To the NSW Department of Planning & Infrastructure

This submission is in response to the CSELR EIS currently on exhibition.

This submission is on behalf of the residents of Alison Road (and neighboring streets) who have formed a group, Need Alison Road Parking (NAP)

From the residents of Alison Road and Neighbouring Streets, Randwick Precinct

Figure 1A

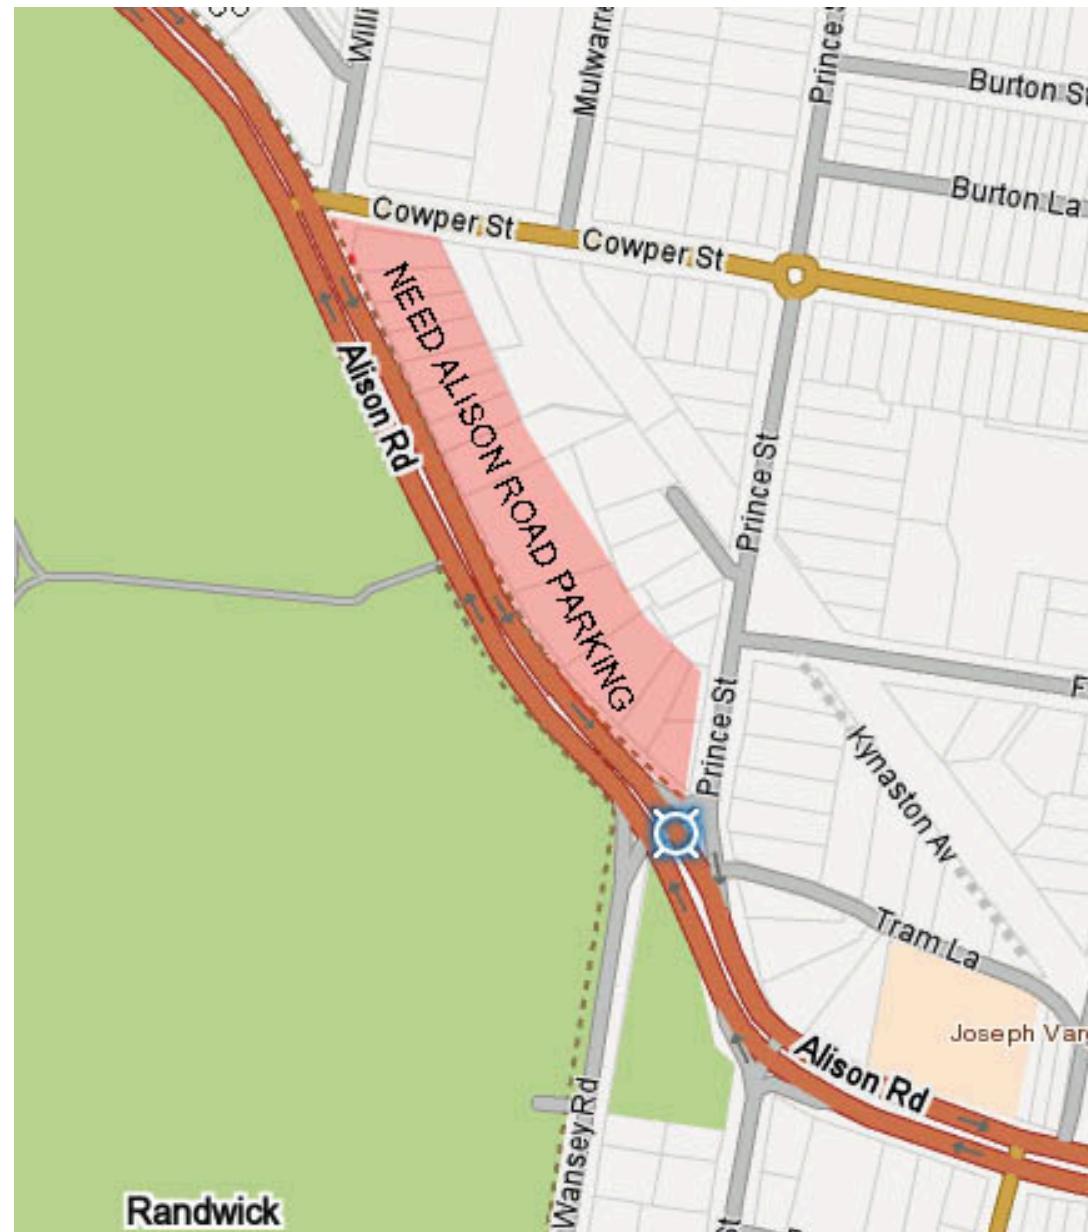
- NAP - Need Alison Road Parking
- This stretch of Alison Road is from Cowper Street on the western side to Prince Street on the eastern side.
- Currently there are 84 car spaces on both the northern & southern sides of the street.
- According to the EIS these are 85-100% occupied at all times (the southern side is only intermittent in use due to morning and weekend restrictions)
- A lack of supply (through the removal of on-street parking) will create severe parking shortages for residents and no alternatives have been suggested.

Figure 1B

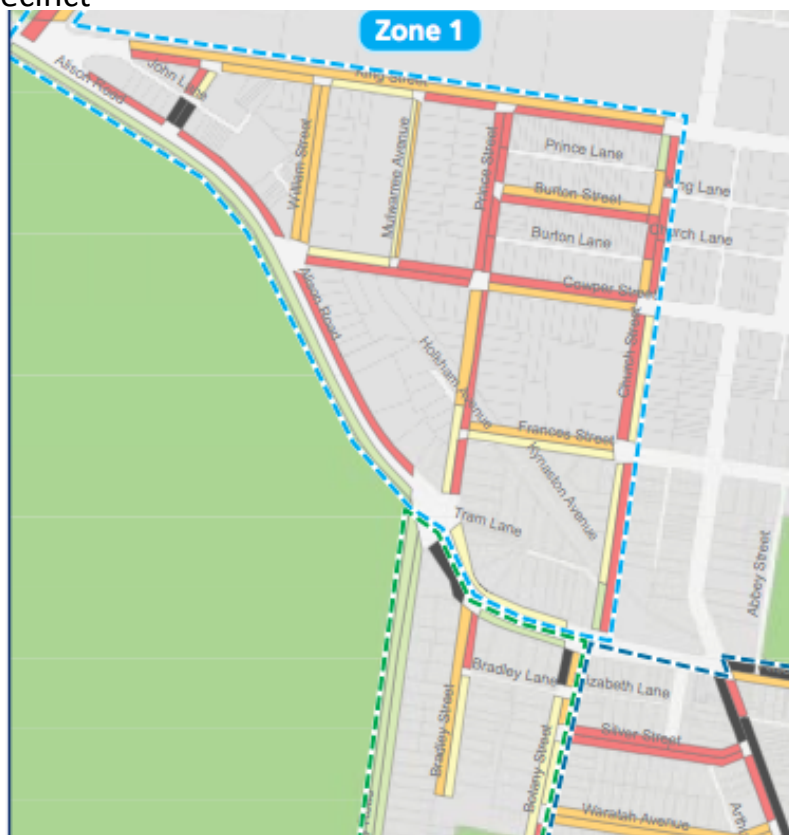
- Since the EIS was released, a residents parking scheme has been installed by Randwick Council on the northern side of Alison Road, validating the need for on-street parking for the residents of Alison Road between Prince & Cowper Streets.
- This has also changed the demographic of parking from 'short stay' high turnover parking to 'long stay' low turnover (residential) parking at peak and inter-peak times.

Figure 5A

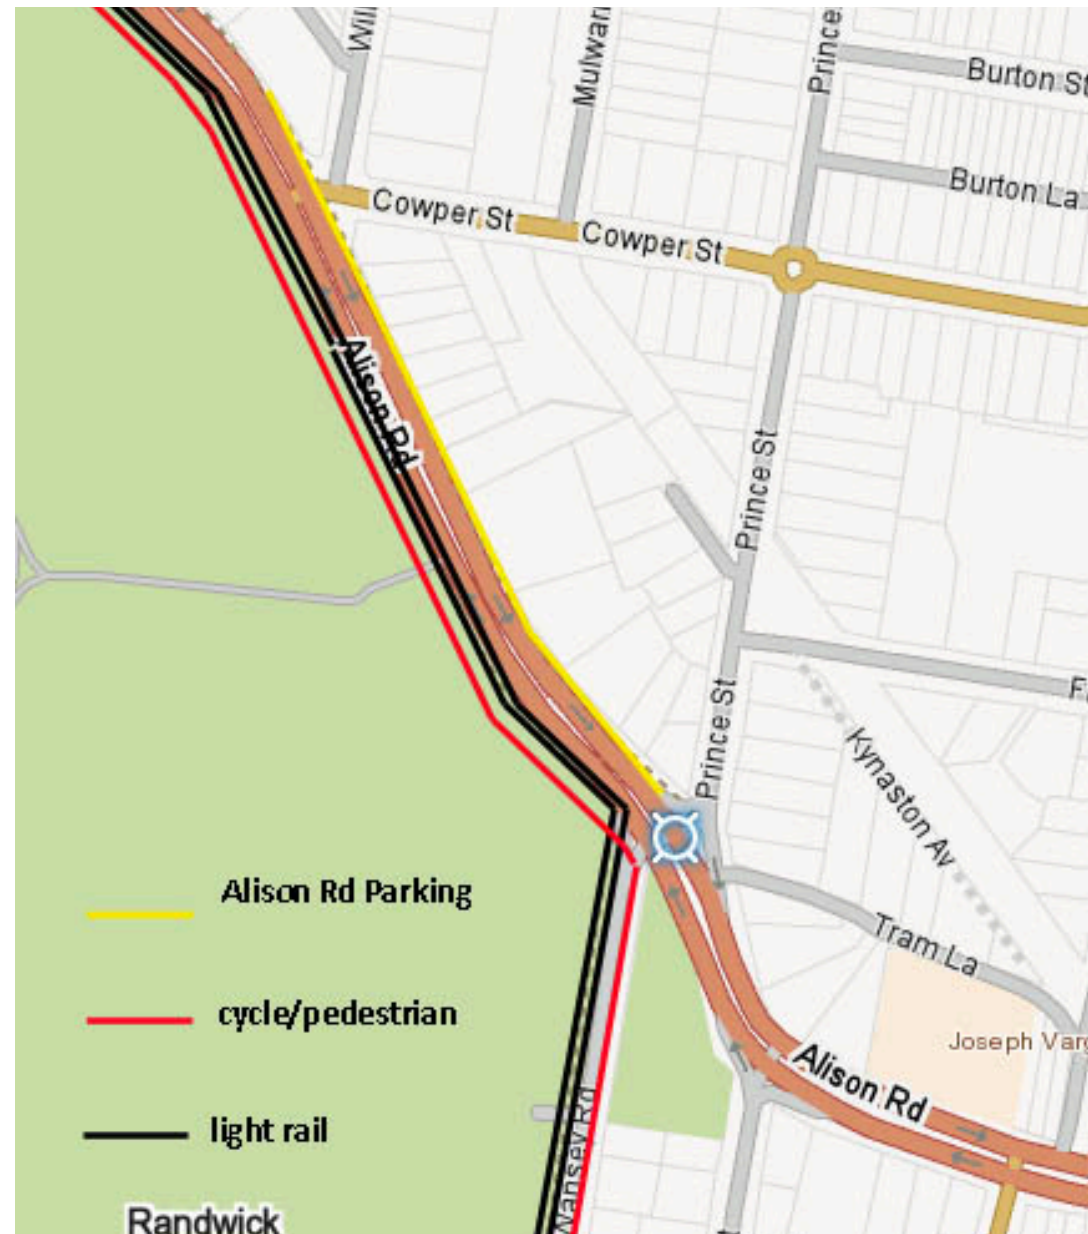
- Option 1 - the 3 lanes on the northern side of Alison Road remain as they are, ie. 1 residents parking lane and 2 traffic lanes travelling east.
- On the southern side the light rail would replace the pavement/cycle lane and take up the first lane of traffic, thereby leaving 2 lanes of traffic traveling west.
- The pedestrian lane/cycle lane could be relocated to the within the racecourse grounds where there already exists a substantial path which would be perfect for both pedestrians and cyclists.
- This option is low impact as no major works would be required on the northern side of Alison Road.
- We would support the retention of the mature trees that line the racecourse and would advocate for no overhead cables to preserve the tree canopies.

- Retain the parking lane on the north side of Alison Road (yellow)
- Retain 2 lanes of traffic on the north side of Alison Road (orange)
- Retain 2 lanes of traffic on the southern side of Alison Road (orange)
- The light rail will take up 1 lane of traffic on the far southern side and the pavement/cycle way (black)
- The pavement & cycle way will be relocated to the existing path within the racecourse grounds (red)
- Retain the mature trees that line the racecourse

Figure 7A

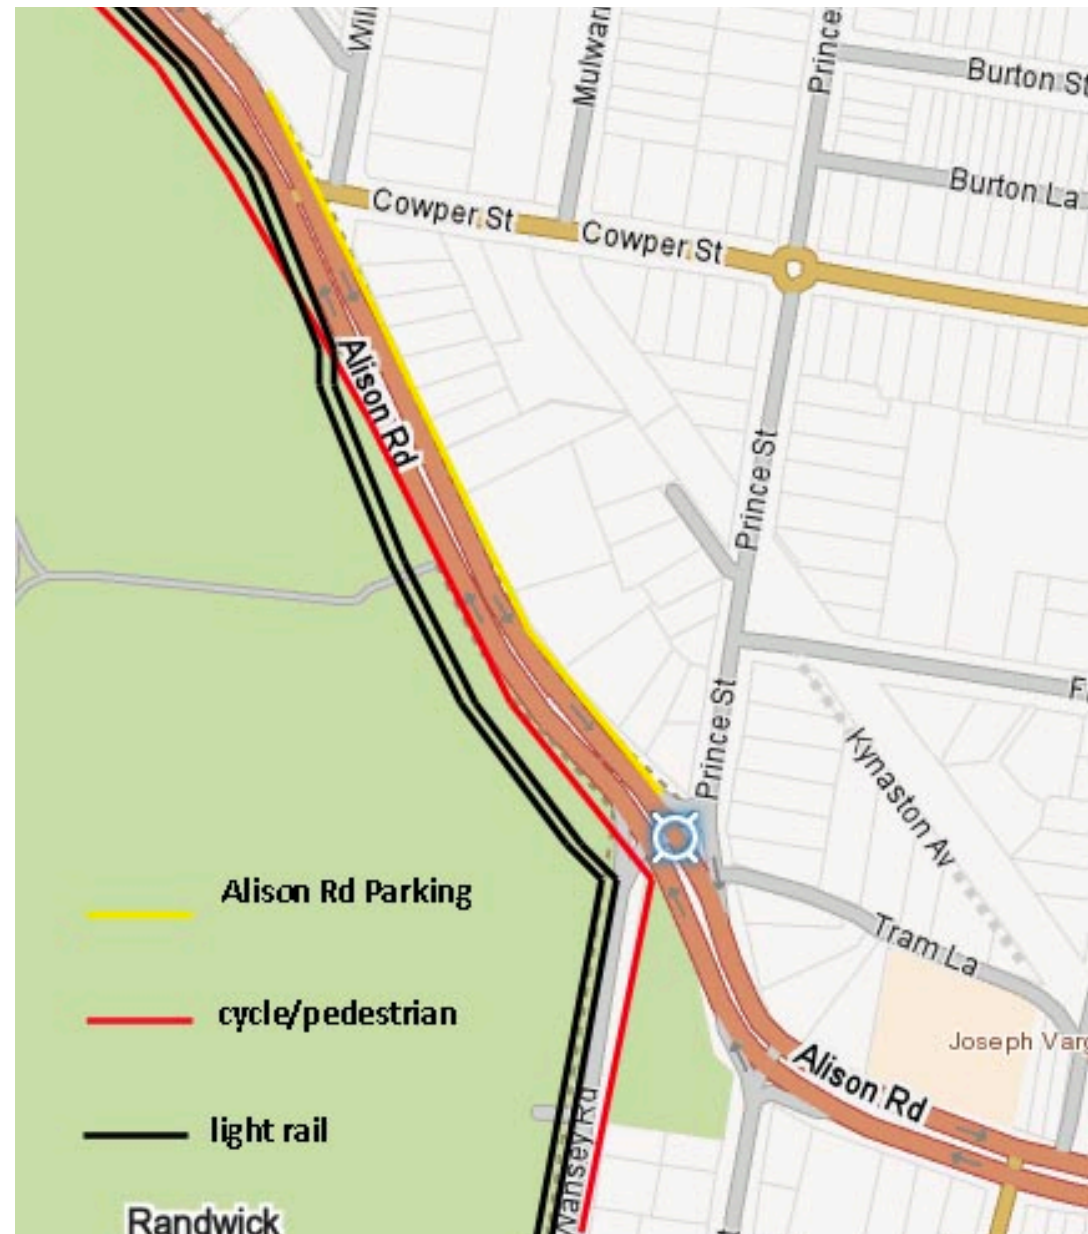
- We suggest that approximately 50m above the Cowper Street intersection, the light rail moves into the grounds of the racecourse, up until the Wansey Road intersection.

- The northern side of Alison Road (before Wansey Rd) would retain it's parking lane and 2 lanes of east bound traffic. The southern side would retain the 3 lanes of west bound traffic, which affords intermittent parking for residents on the southern side.

- The light rail is a sufficient distance from the racecourse track so it will not 'interfere' with race day activities.
- The pedestrian lane/cycle lane could be retained on the southern side of Alison Road to the north of the Light Rail Tracks.

- This option is low impact as no major works would be required on the upper section of Alison Road below the Wansey Road intersection.
- This would save the 84 car spaces on Alison Road.

- This would also save the significant mature trees which line the racecourse and are visually and historically important to the area. NAP strongly objects to their removal.

- Retain the parking lane on the north side of Alison Road (yellow)
- Retain 2 lanes of traffic on the north side of Alison Road (orange)
- Retain 2 lanes of traffic on the southern side of Alison Road (orange)
- The light rail will move into the racecourse 30m above the Cowper St intersection.
- The pavement & cycle way will be retained between Cowper St & Wansey Rd.
- Mature trees will be saved.
